CUMBERLAND
CITY COUNCIL

Ref: OA2021/0010
DPIE Ref: SSD-19425495

Subject: Request for Comments - State Significant Development (SSD)
Application No: SSD-19425495
Property: 132-144 Warren Road SMITHFIELD NSW 2164,
Proposal: Proposed construction and 24/7 operation of Materials Recovery Facility (MRF) processing up to 150,000 tonnes/annum non-putrescible co-mingled recycling

Figure 28 Proposed Option 2 Scenario - 1% AEP Flood Depth Map

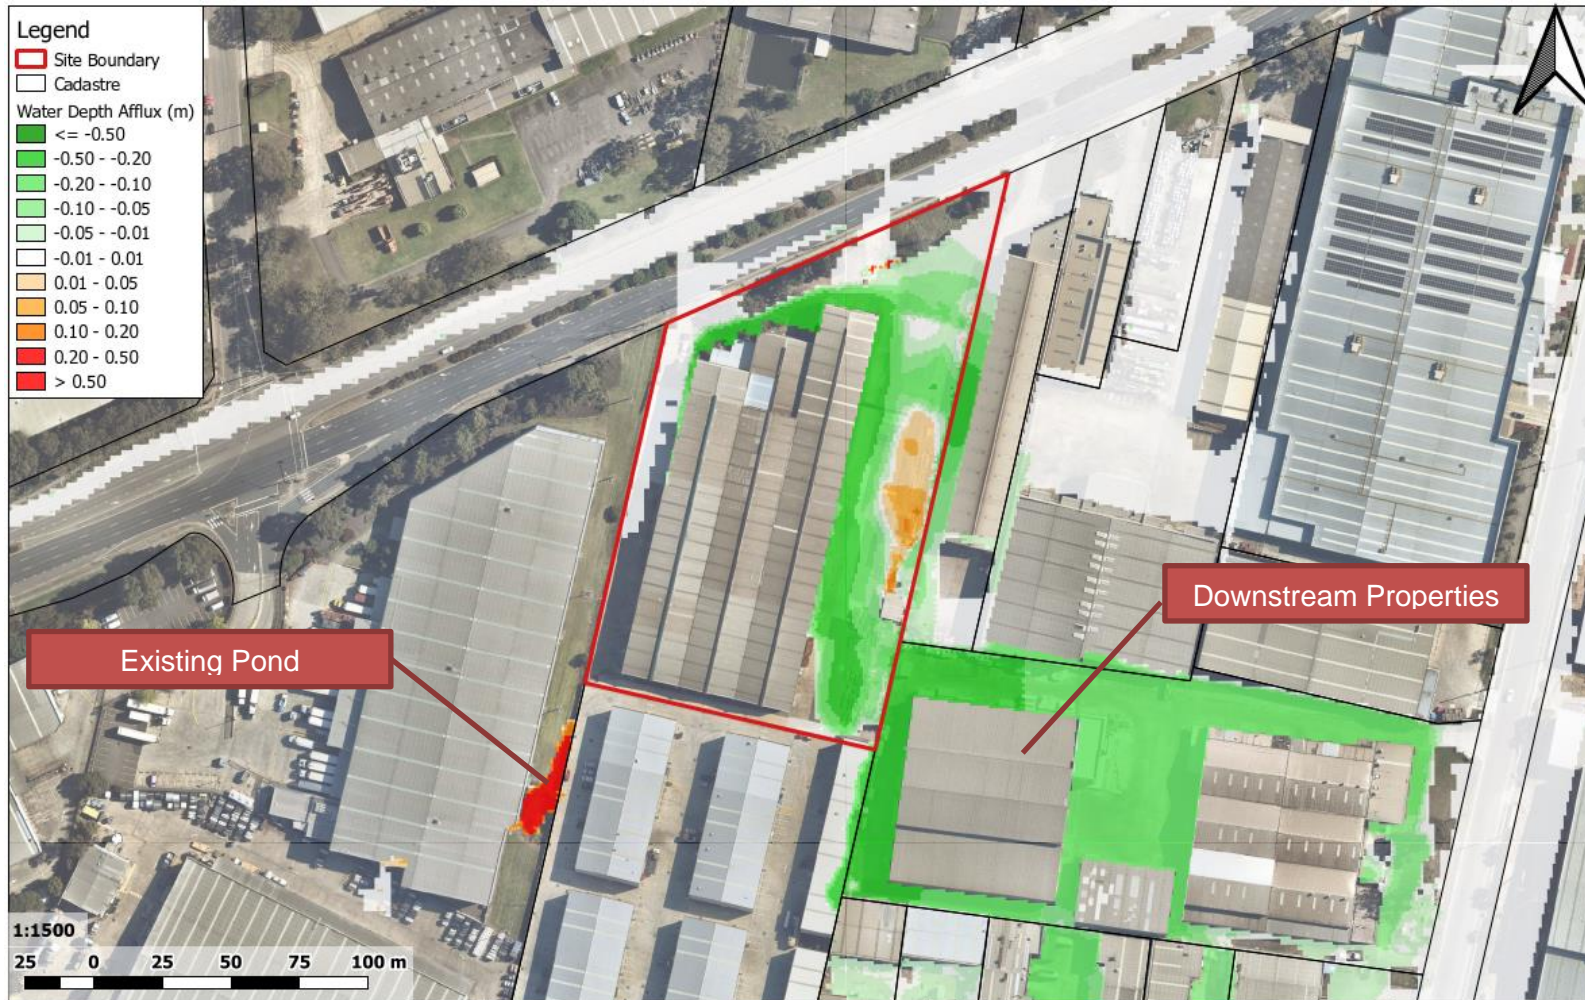
It appears proposed weighbridge located in the southern side of the building if affected by 1% AEP flooding. The matter shall be addressed as part of the proposal. Flood evacuation plan shall be incorporated as part of the development.
